From: Michael Eastham <Michael.Eastham@arun.gov.uk>
Sent: 17 April 2020 18:15
To: Planning.Responses <Planning.Responses@arun.gov.uk>
Subject: FW: BN/85/19/DOC - The Lillies

Please upload the email below from ADC Drainage onto Ocella for the discharge of condition application BN/85/19/DOC at The Lillies, Yapton Road, Barnham.

Subject: RE: BN/85/19/DOC - The Lillies

## TYPICAL MANHOLE DETAIL TYPE B

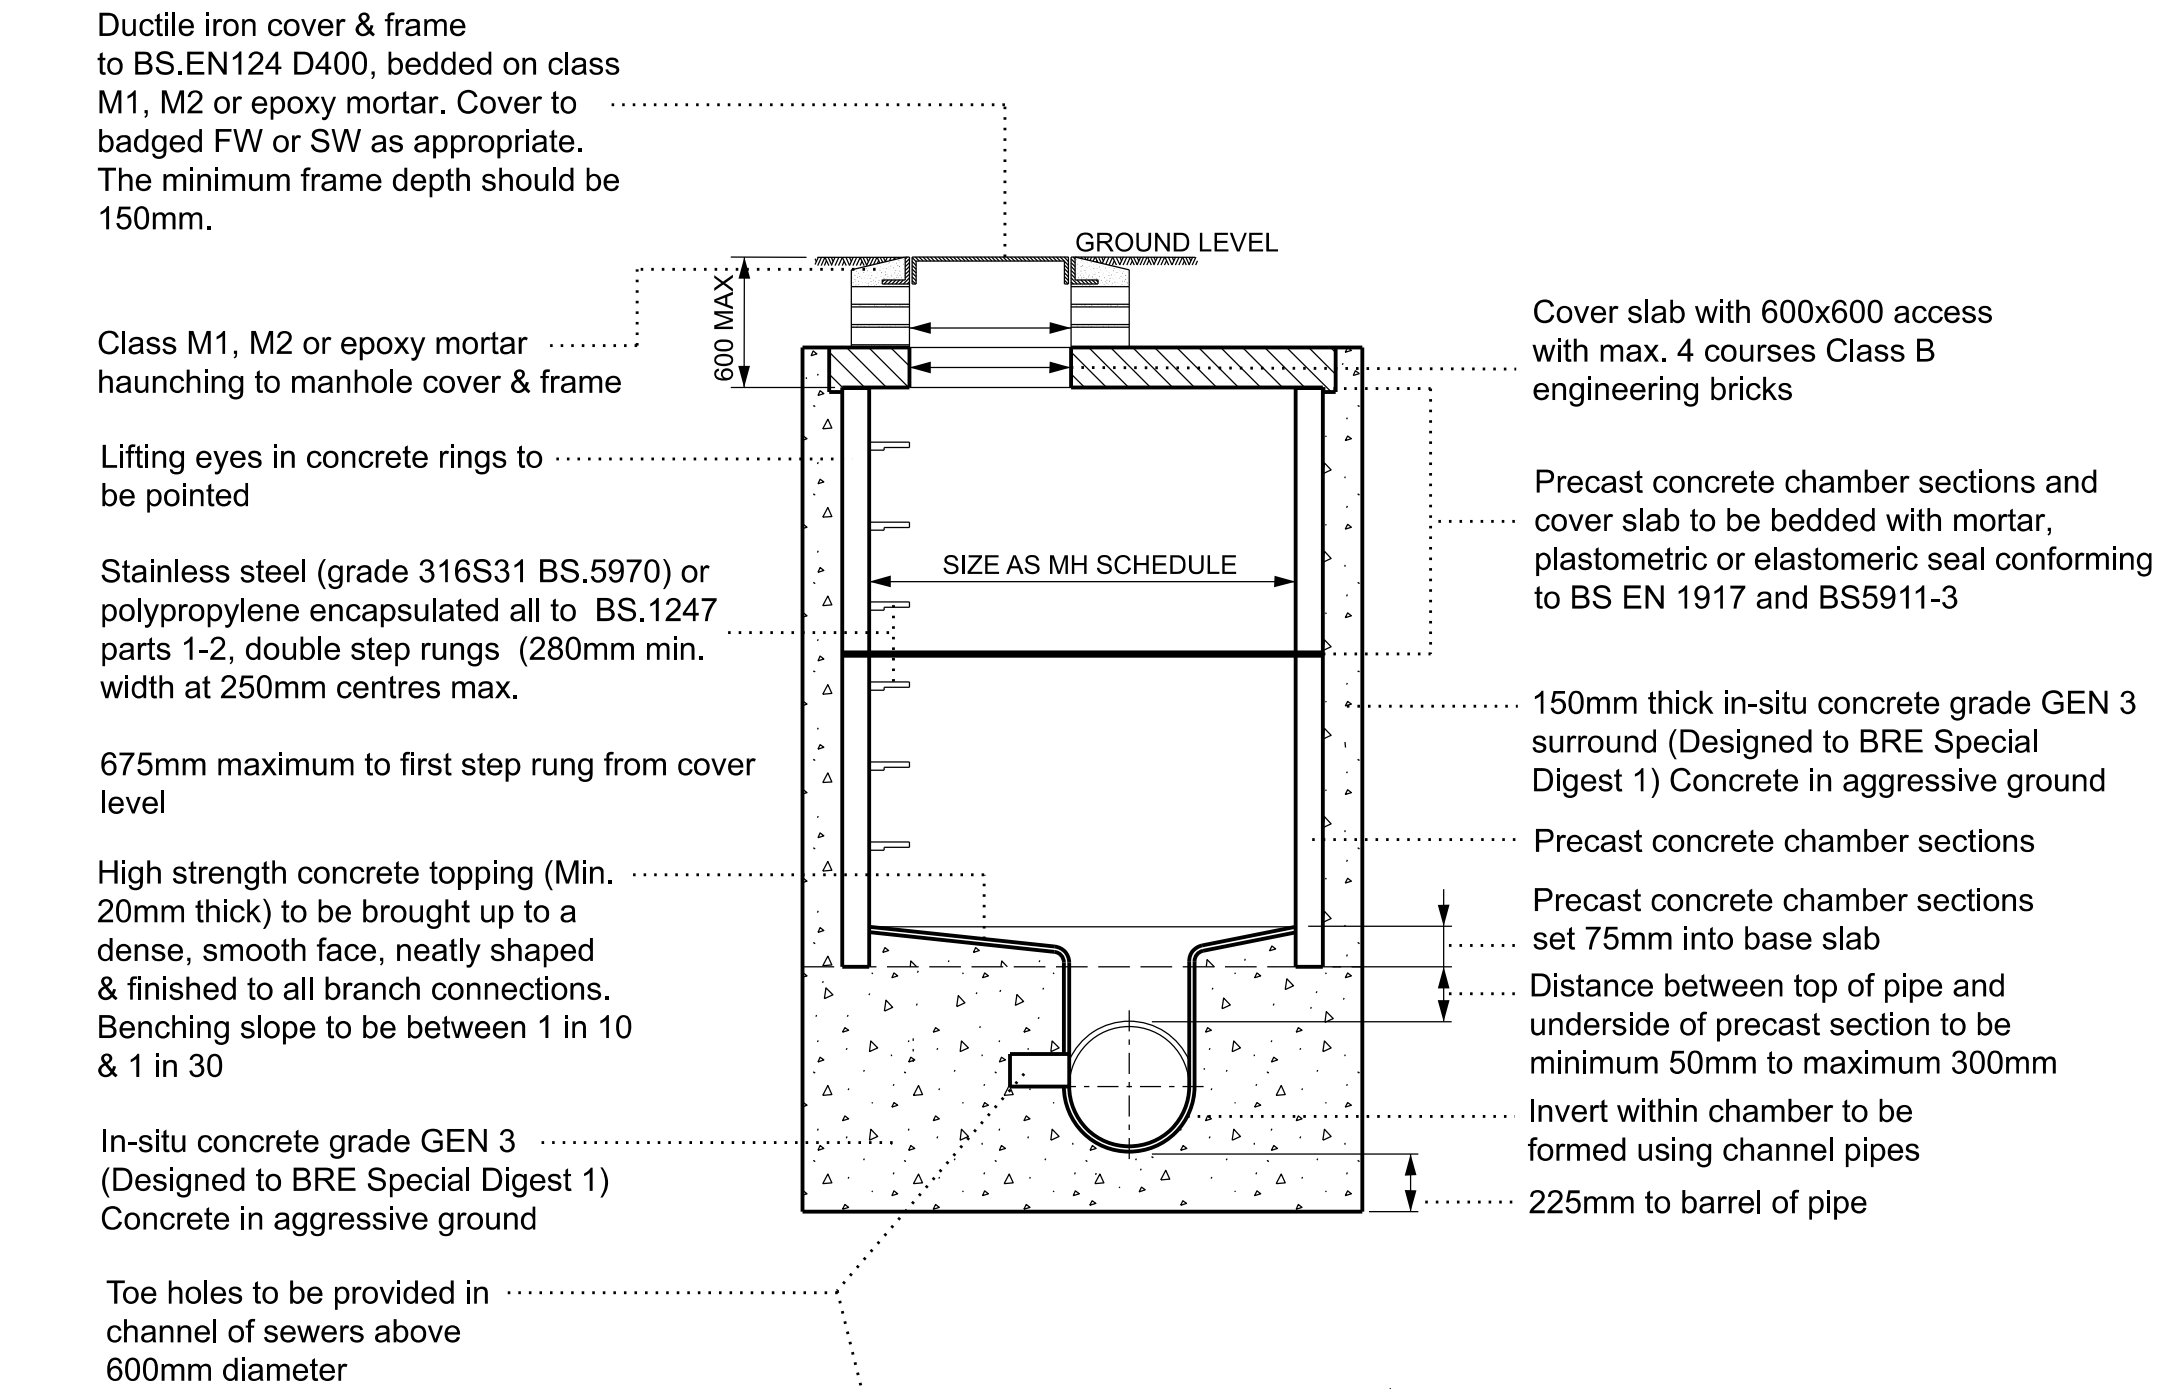
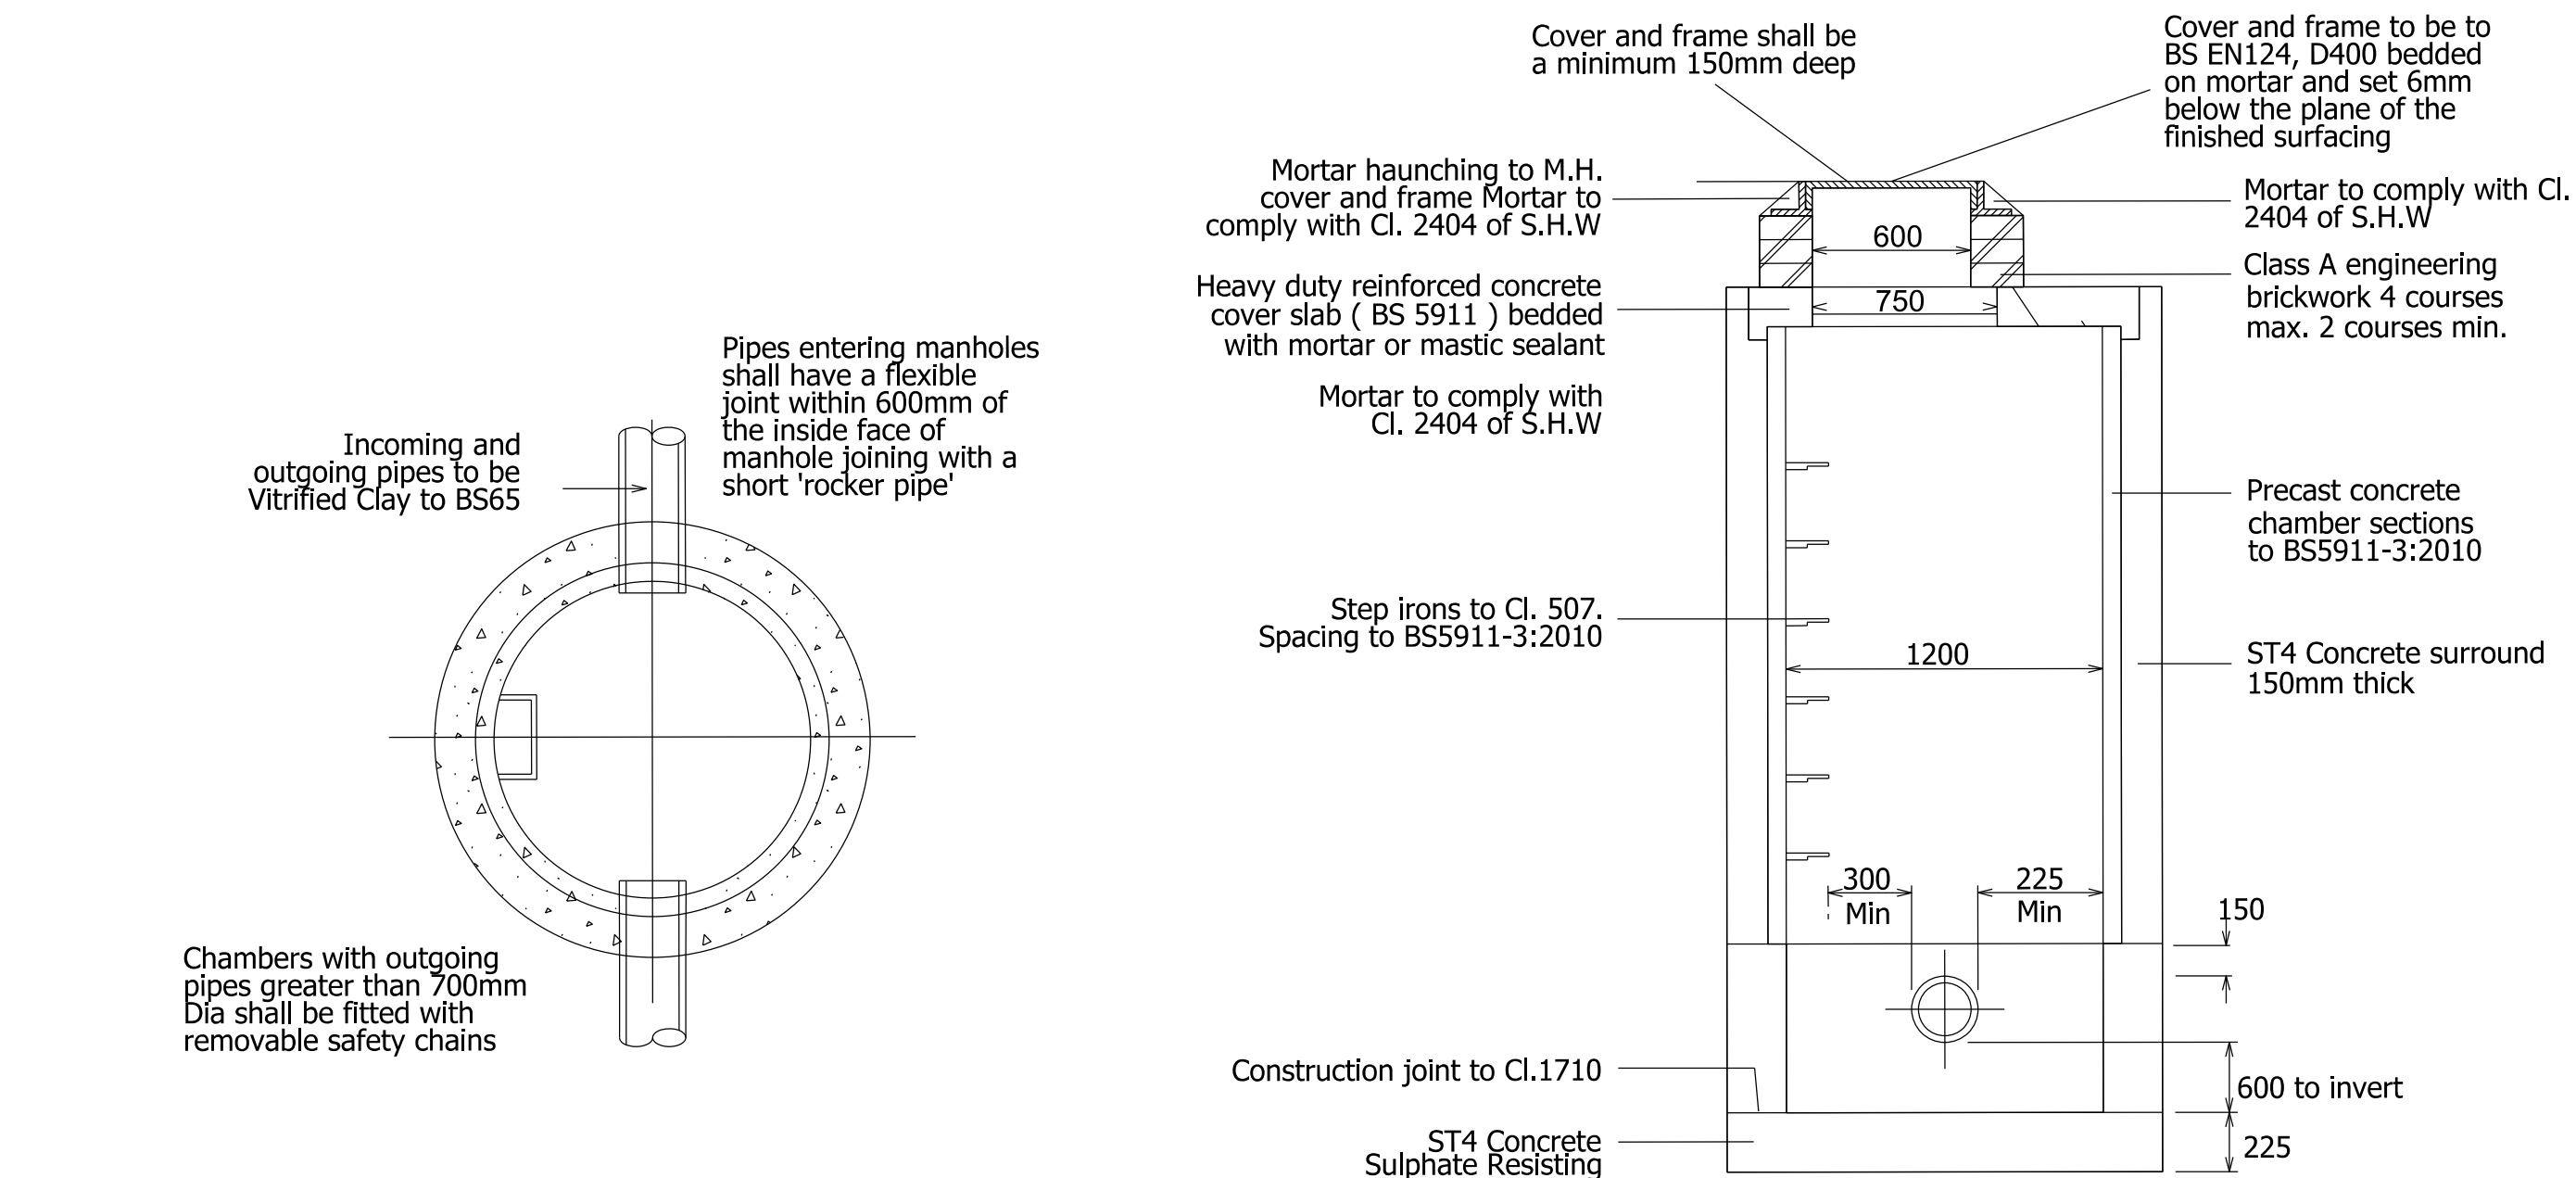
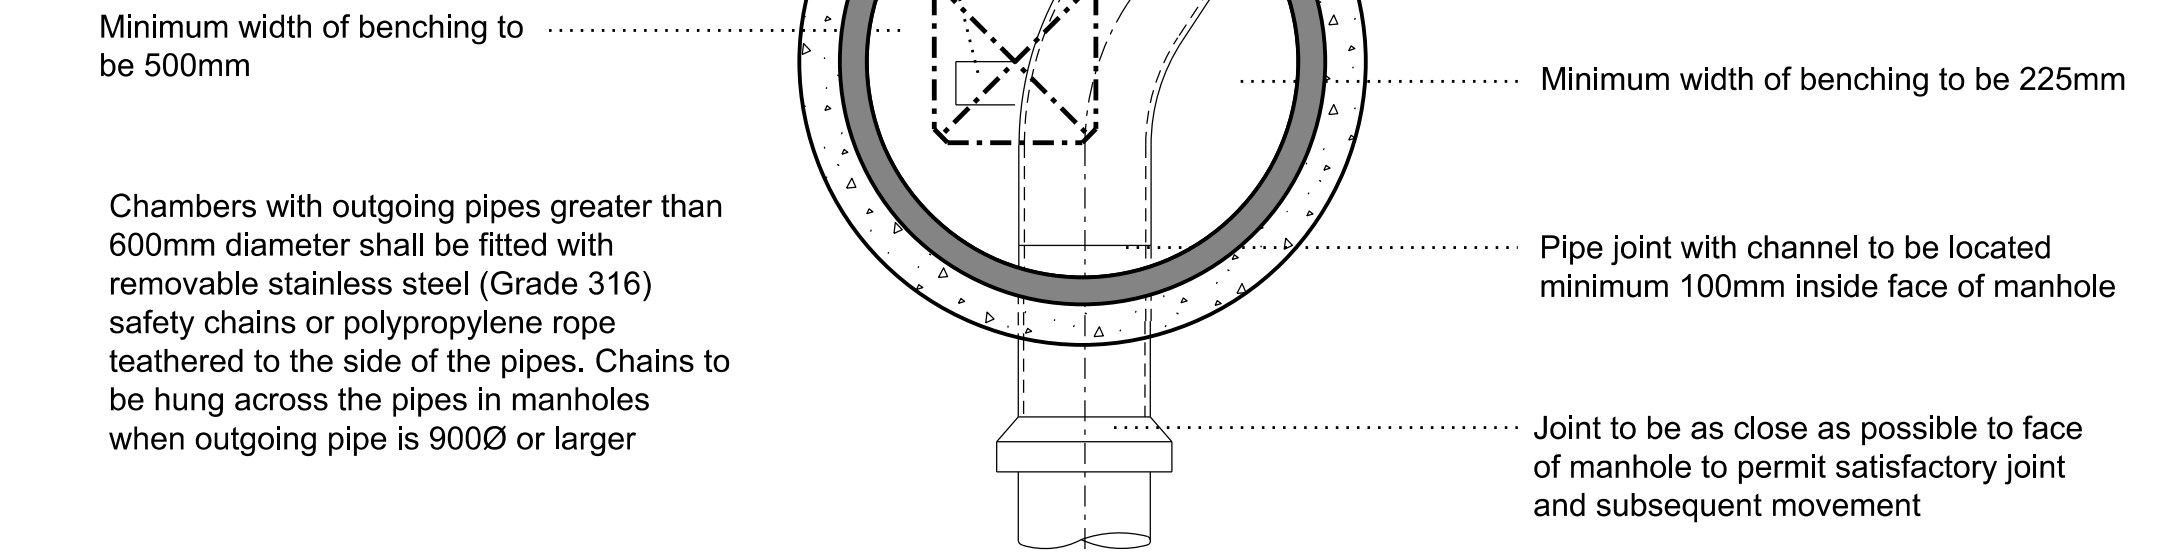
14. Ok
15. Type B manhole noted. Since these will be adopted, Southern Water confirmation will be required in respect to the use of this manhole type for shallower manholes ie. S3, S4, S5 for example. Please include a manhole schedule, alter key legend or add the manhole types to the long section, so it is clear which manholes this construction refer's too.

## CLASS S BEDDING DETAIL

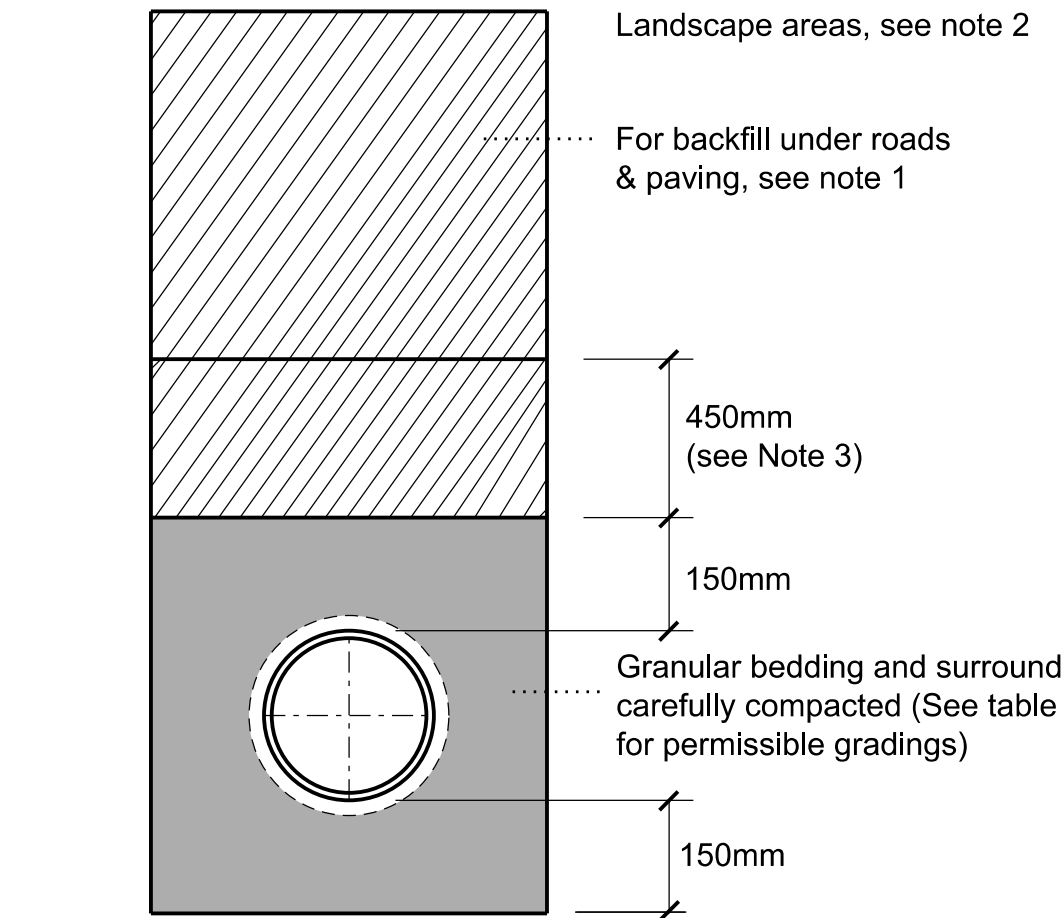
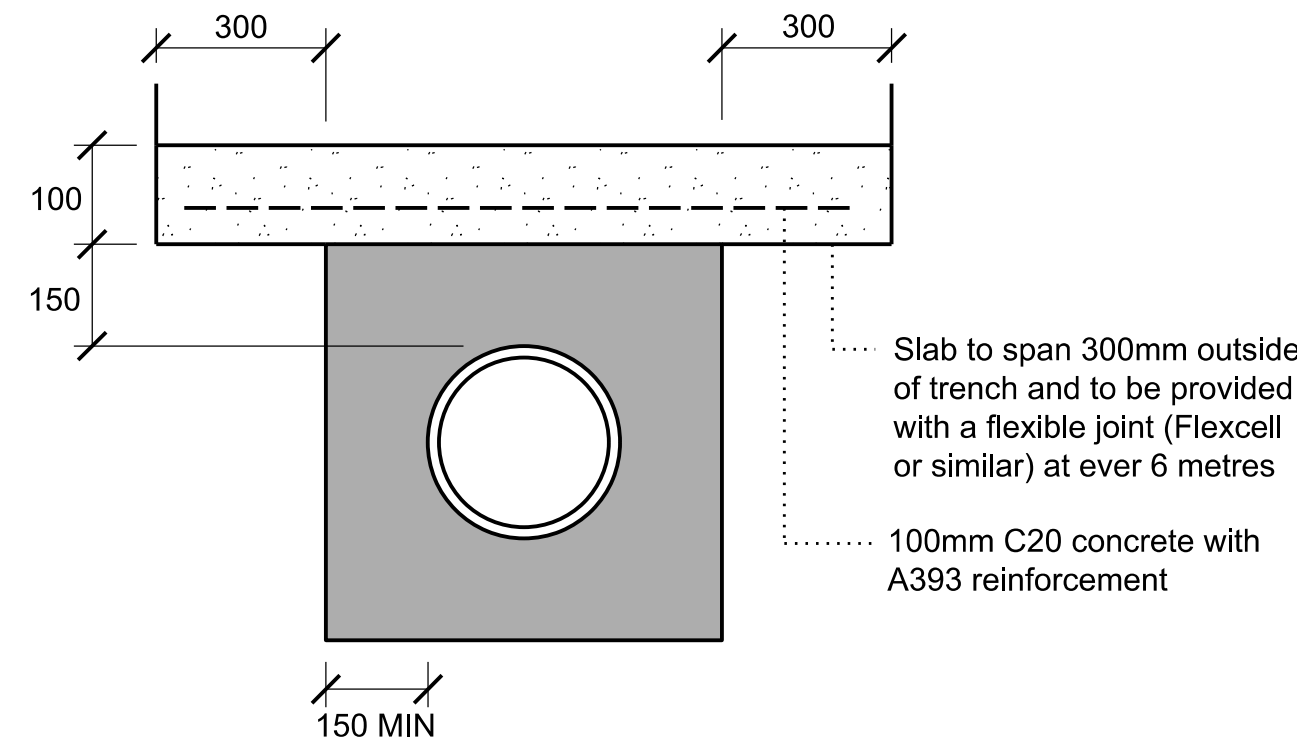
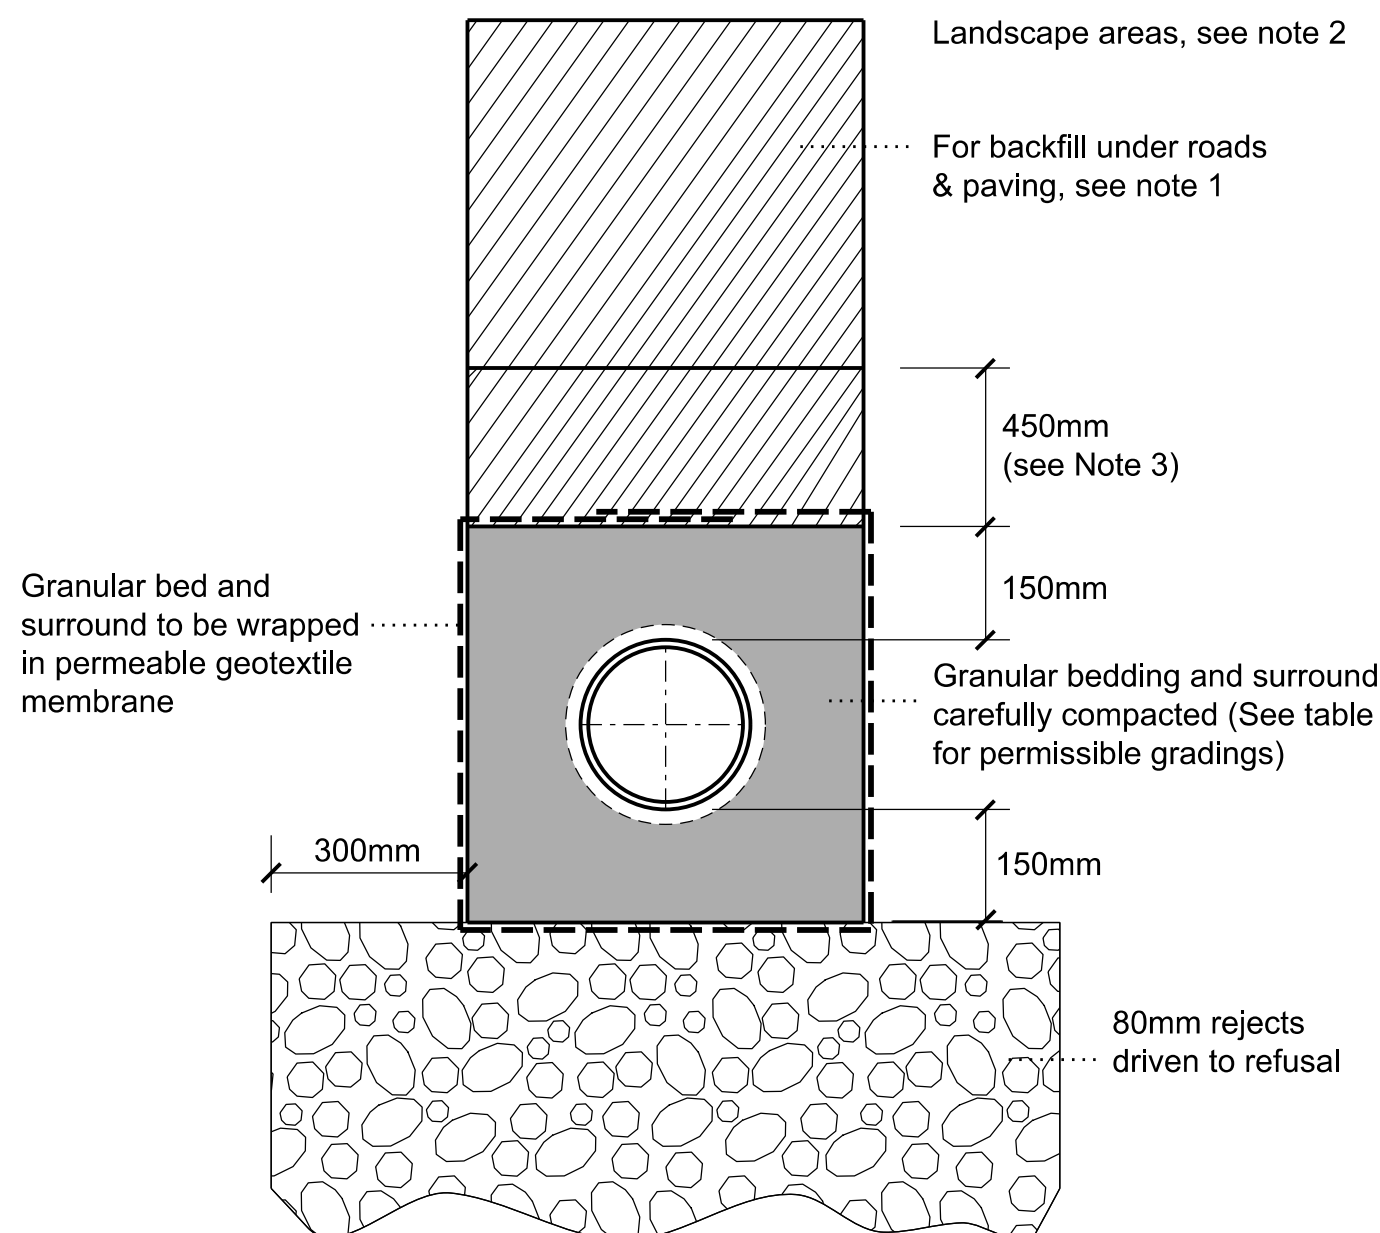
16. Class Z detail not included but I note the concrete protection slab detail with is fine. Just specify granular bed and surround to the pipe and label as Class S[S] as referred to in notes on long sections, etc. Specify depth of cover for class S bedding use. Bedding details refer to rigid 'jointed' pipes although flexible 'jointed' pipes will be used.
